The proposal has been reviewed and I enclose the Environment Agency's comments on:
Clymping Mill Climping Street Climping BN17 5RN

LPA ref: CM/34/17/L

Our ref: HA/2018/120087/01-L01
Your ref: CM/34/17/L
Date: 31 January 2018

LISTED BUILDING CONSENT FOR DEMOLITION OF PREFABRICATED FORMER PRIVATE SCHOOL BUILDING AND MILL LODGE RESIDENTIAL UNIT. REFURBISHMENT OF EXISTING MILL TO RETAIN AND REFURBISH EXISTING DWELLING AND FLATS 1 & 2 (ADJOINING) WITH 2NO. ADDITIONAL DWELLINGS. REFURBISHMENT OF MILL COTTAGE AND MILL THATCH (UNITS 1 & 2) AND ERECTION OF 1NO. NEW-BUILD FLOATING POND-HOUSE WITHIN FEATURE POND. DEPARTURE FROM THE DEVELOPMENT PLAN. THIS APPLICATION ALSO LIES WITHIN THE PARISH OF LITTLEHAMPTON.

EA's Online Flood Map for Planning (Rivers and Seas)

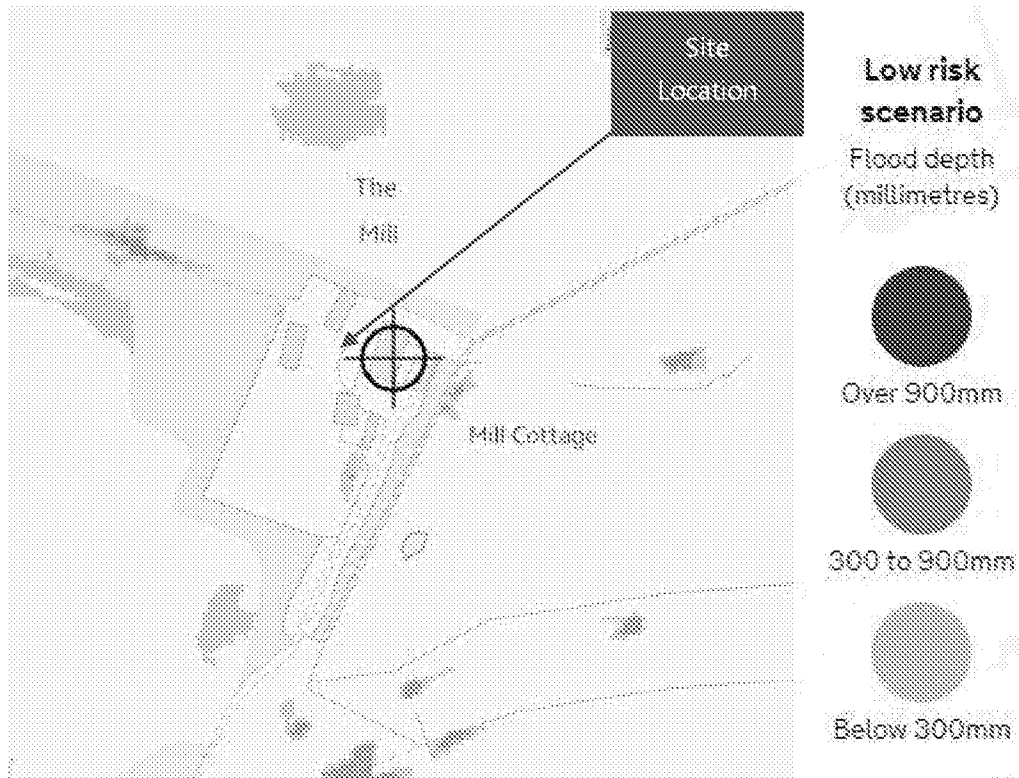
According to the Environment Agency Map for Planning (Rivers and the Sea) the site is partially located in Flood Zone 2 and 3 (Medium and High Risk) with all the buildings shown to be in Flood Zone 1 (Low Risk).

When considering the effect of climate change, in particular the undefended 1 in 200 year flood event plus an allowance for climate change, the entire site is shown to be at risk of flooding, as suggested by the data provided in the Product 4 (Appendix B of the FRA). Section 2.6 of the FRA erroneously states that 3.76m AOD is the undefended 1 in 200 year flood event plus an allowance for climate change for node 7 (the closest to the proposed new pond house). From Table 1 in Appendix B of the FRA it is clear that this level is 4.76m AOD instead (node 7). Therefore the proposed finished floor levels for the new pond house of 4.06m AOD (Section 3.4 of the FRA) will be 0.7m lower than the design flood (undefended 1 in 200 year flood event, plus climate change). No further flood mitigation measures are proposed.

We would recommend finished floor levels to be set at least 300mm above 4.76m AOD.
